From: Andrew Wood <Andrew.Wood@arun.gov.uk>
Sent: 04 November 2019 10:39
To: Peter Terry [REDACTED]
Cc: Planning.Responses <Planning.Responses@arun.gov.uk>
Subject: FW: WA/7/19/RES - Lanes End, West Walberton Lane - Additional information request

WA/7/19/RES - Lanes End, West Walberton Lane - Additional information request

PJ DEVELOPMENTS LTD 2 Square Chambers 23 High Street Emsworth PO10 7AQ Tel: 0843 289 3430 Email: enquiries@pjdevelopmentsltd.com	
PROJECT: FORMER LANES END	
SITE PLAN OUTLINE PLANNING APPLICATION	
DATE: JANUARY 2019	DWG. NO 19-001 PL02
SCALE @ A1: 1:200	
REV: C

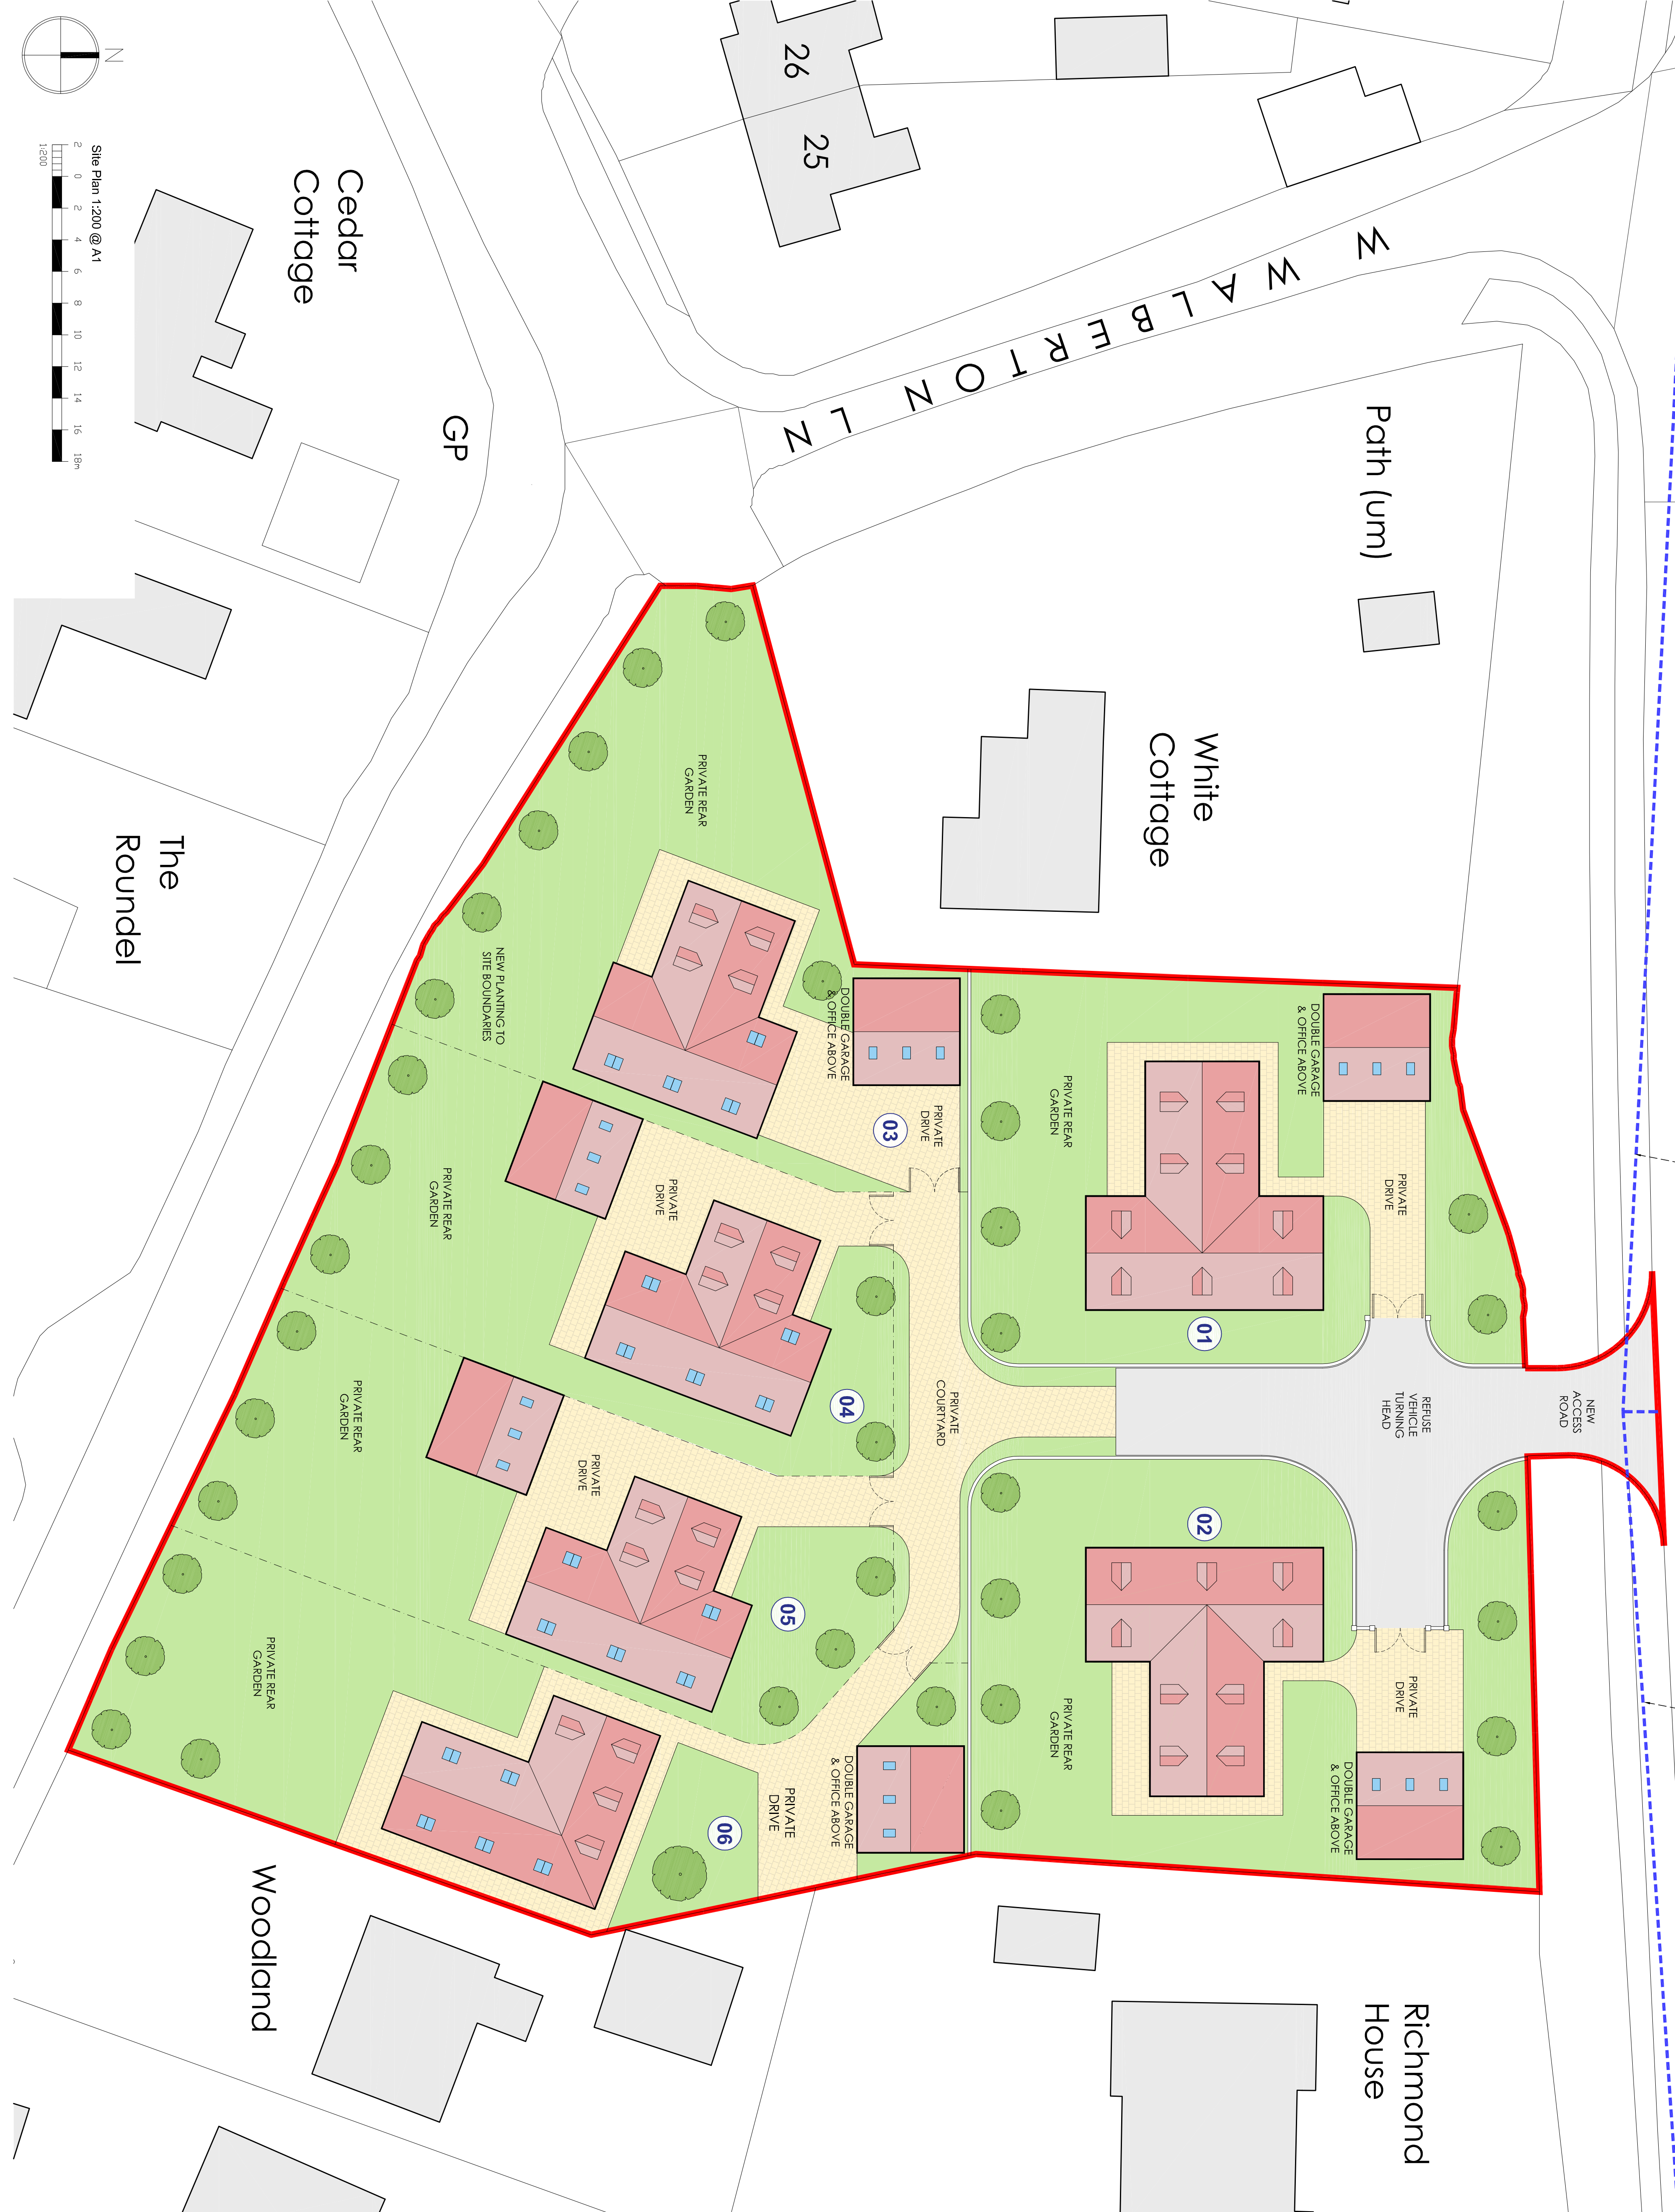
1. Amend the layout to ensure that a minimum of 9 metres exists on from blank gable end (or obscure glazed windows non opening below 1.7 metres in height) of nearest proposed house to gable end of 'Woodlands' which currently incorporates sole habitable room windows.
2. Remove second storey of houses/rooms in roof. 3 storey townhouses would not be acceptable in this location

1, Happy to amend property six to make a nine metre distance.

PLOTS 1 AND 2 FLOOR PLANS AND ELEVATIONS

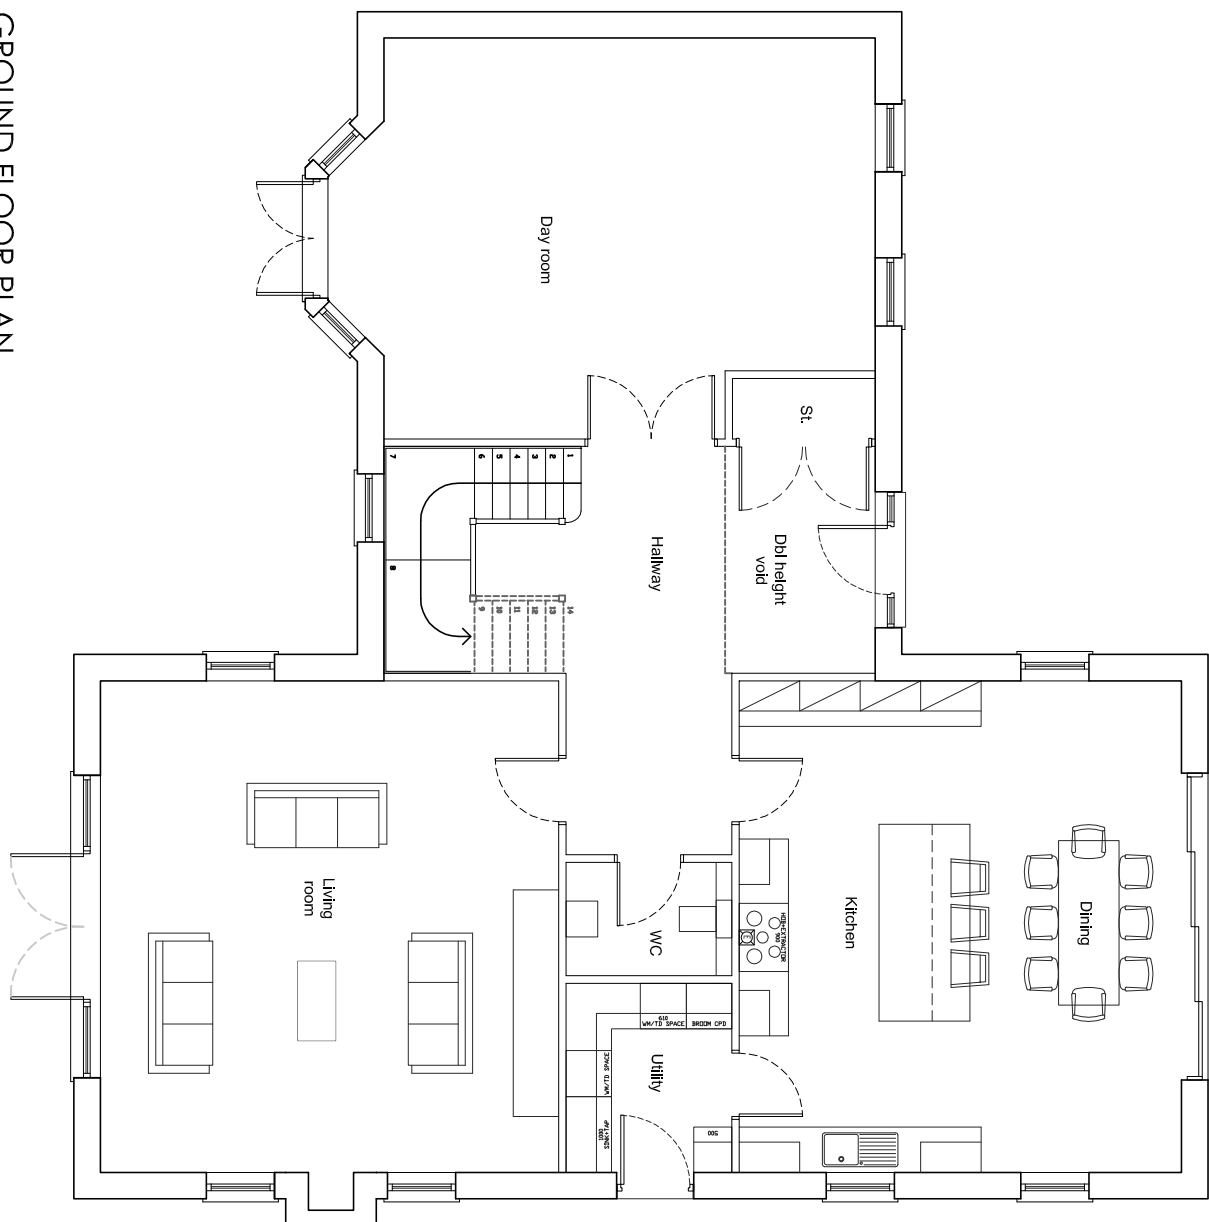
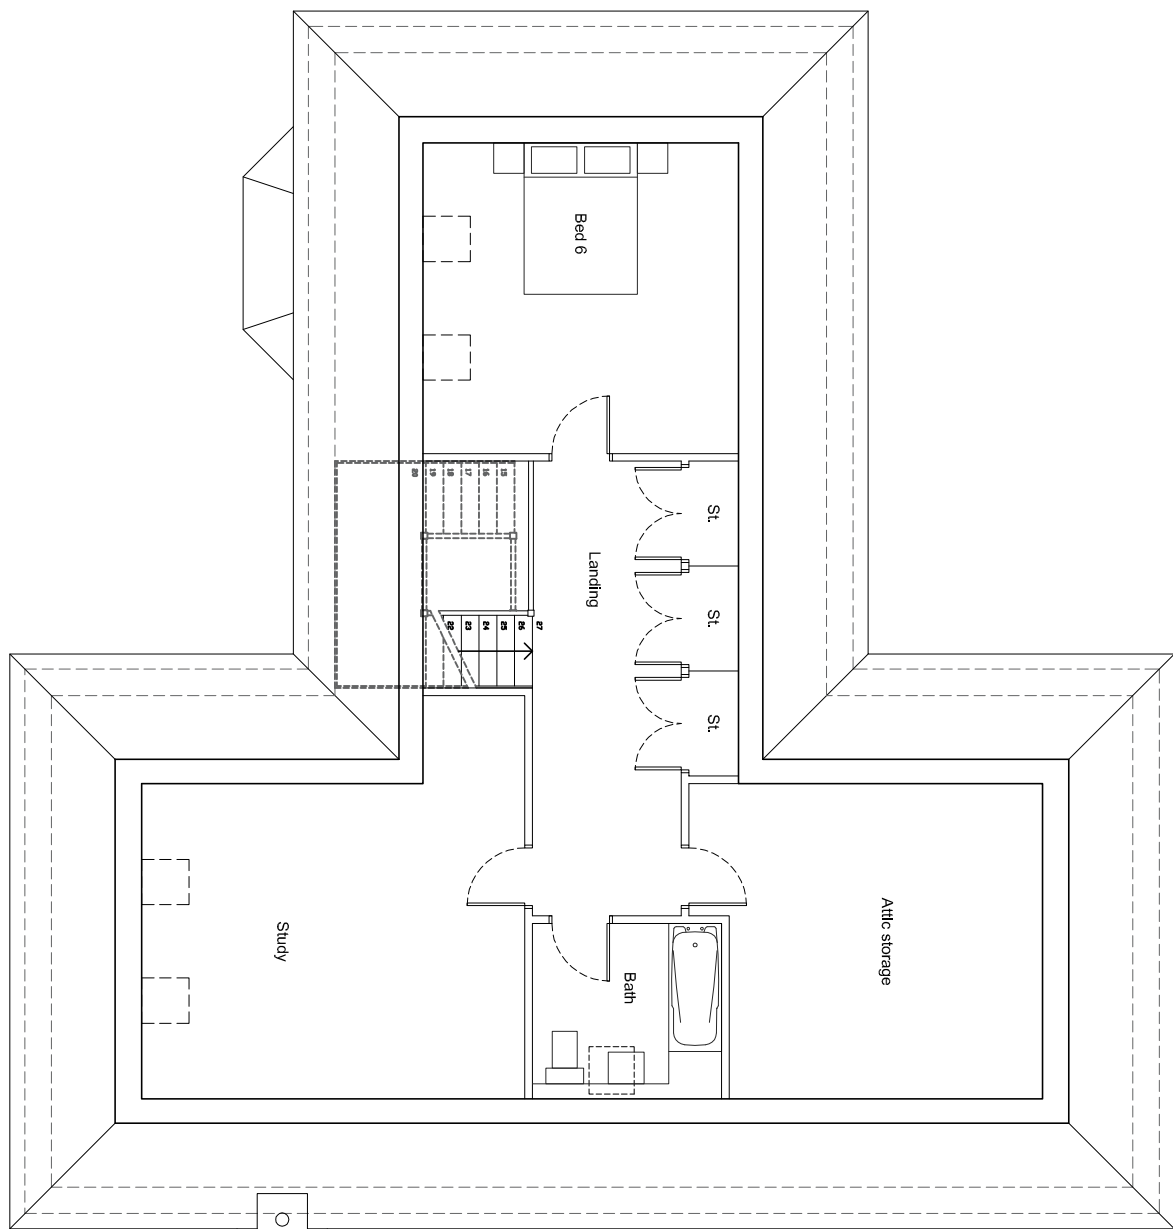
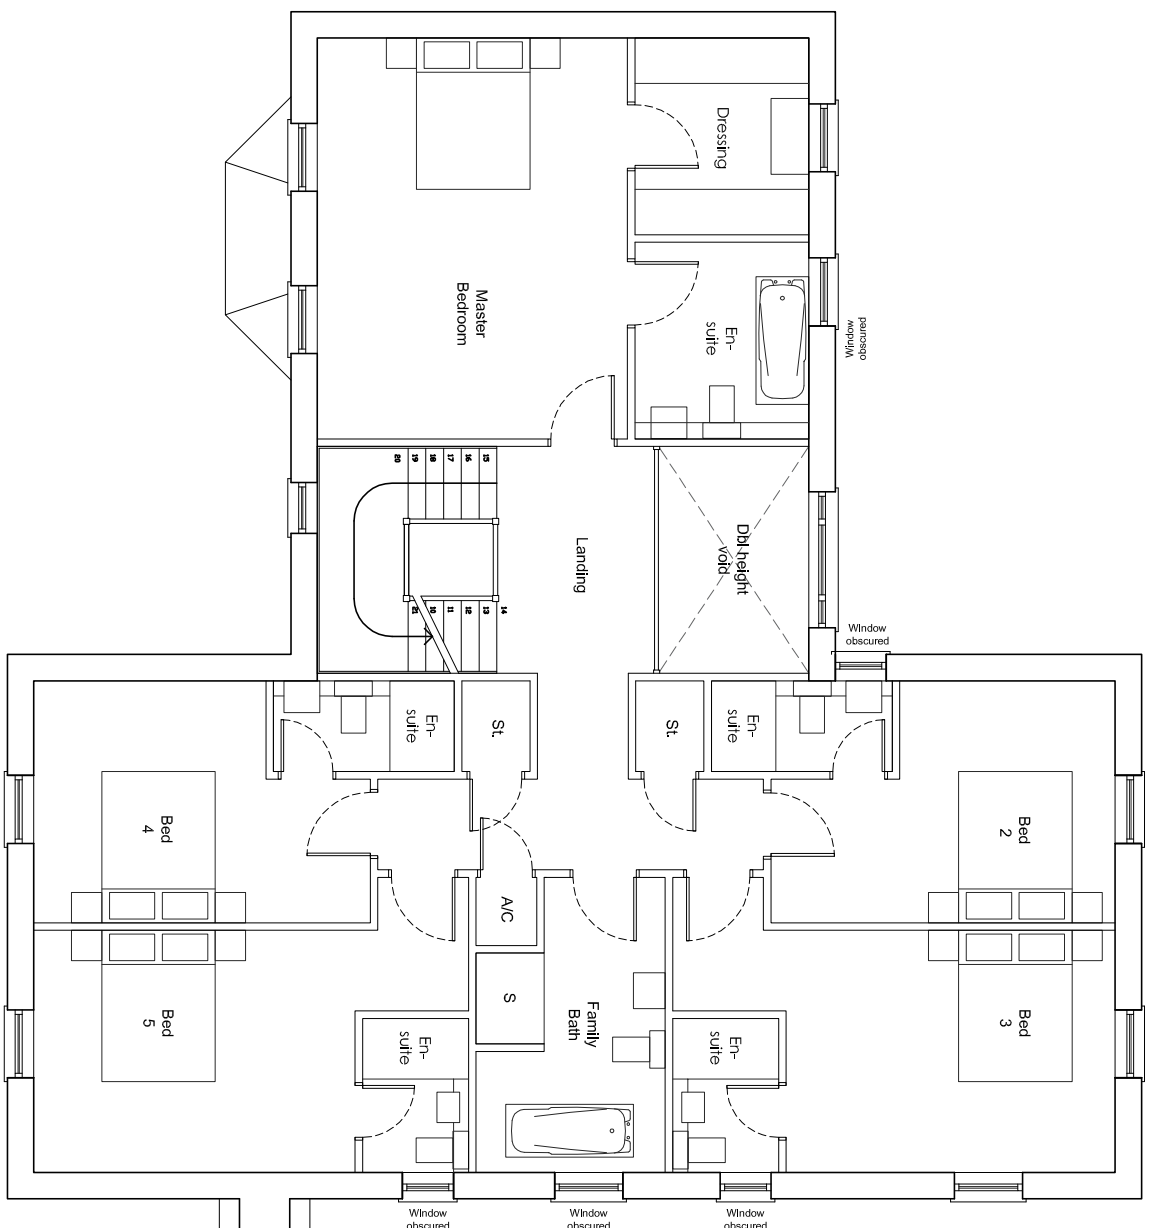
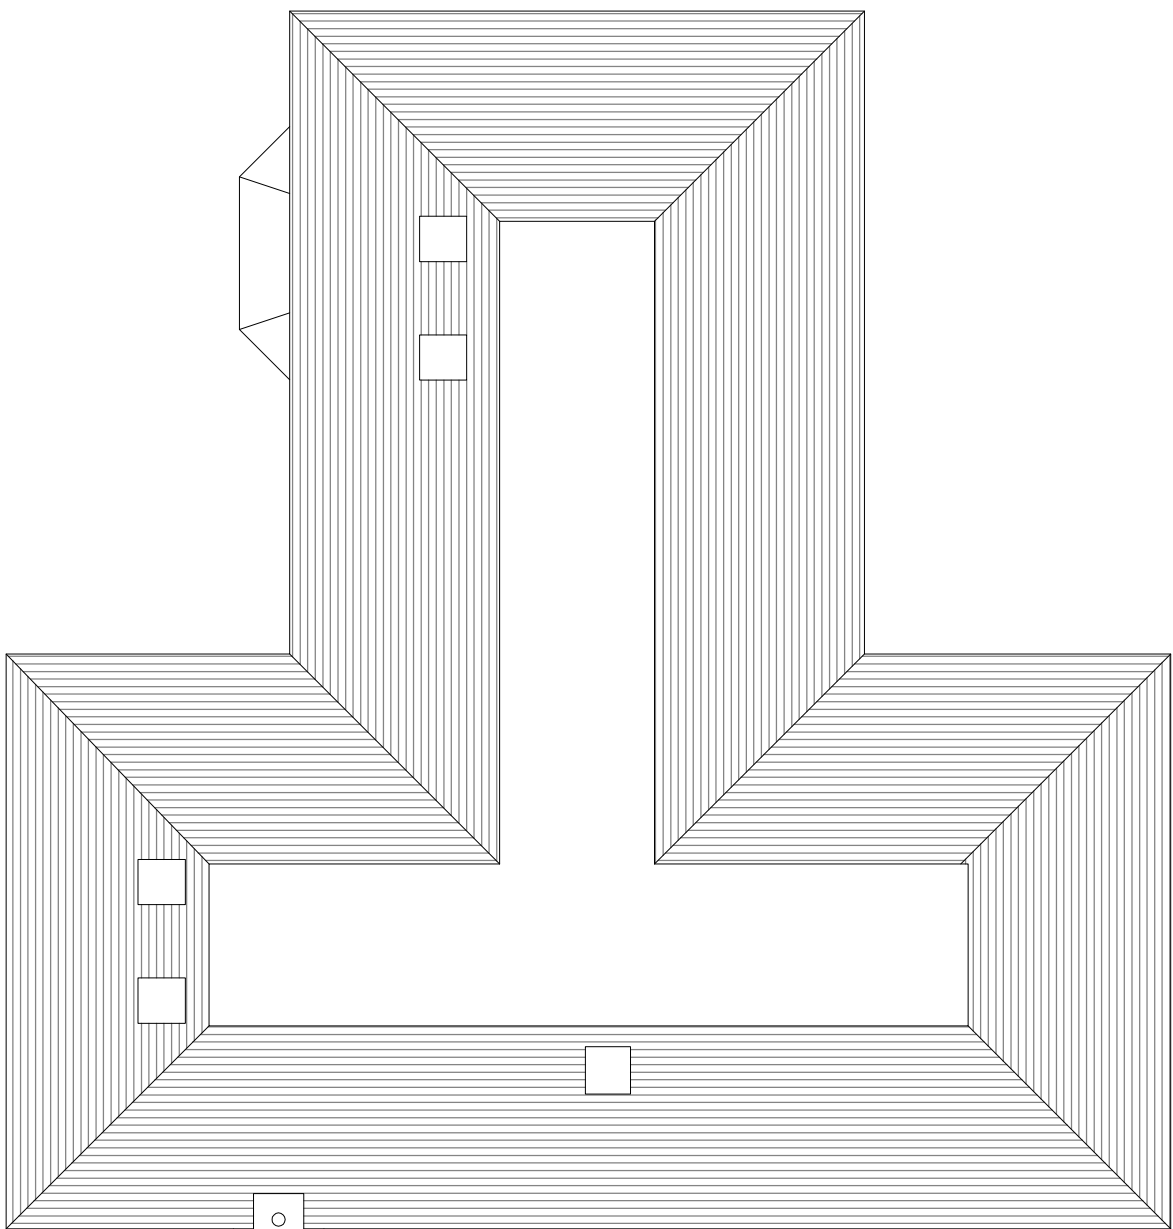
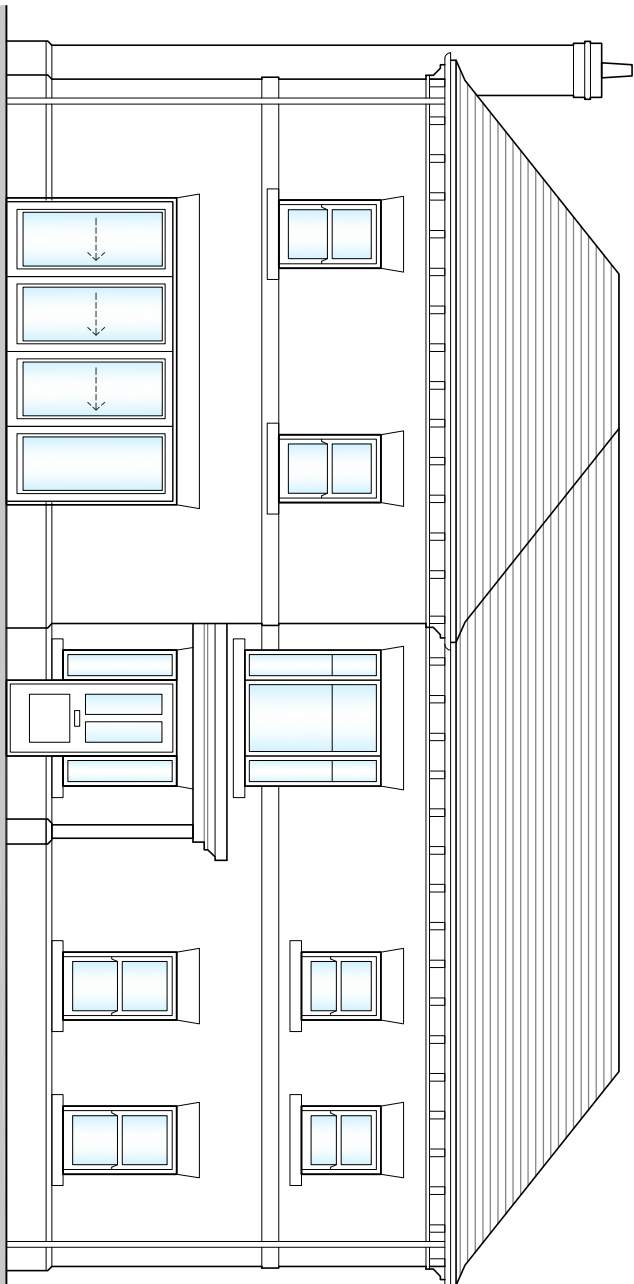
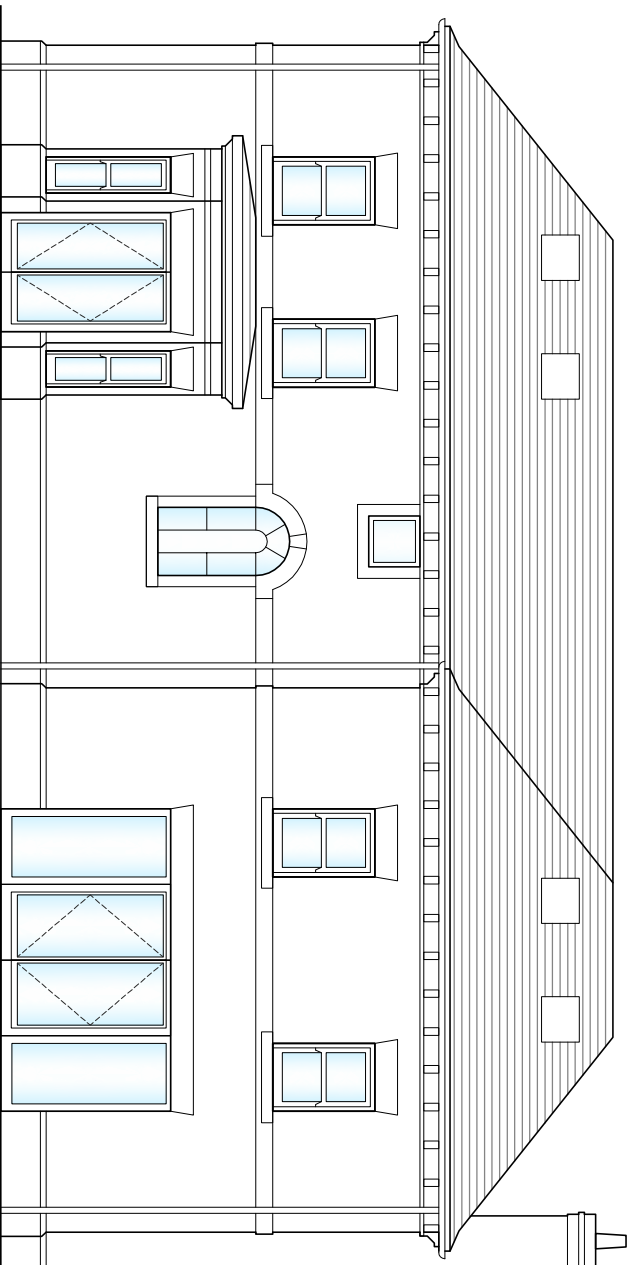
the issue with the rooms in the roof is that the appearance of the dwellings will be of a town house which is simply not appropriate in this location. I would strongly advise you to remove this element from the scheme. To avoid the risk of the development being viewed as 'out of character' in the area and contrary to policy D DM1 of the Arun Local Plan. I have discussed the matter with my line management team and everyone is of the same view in this case.
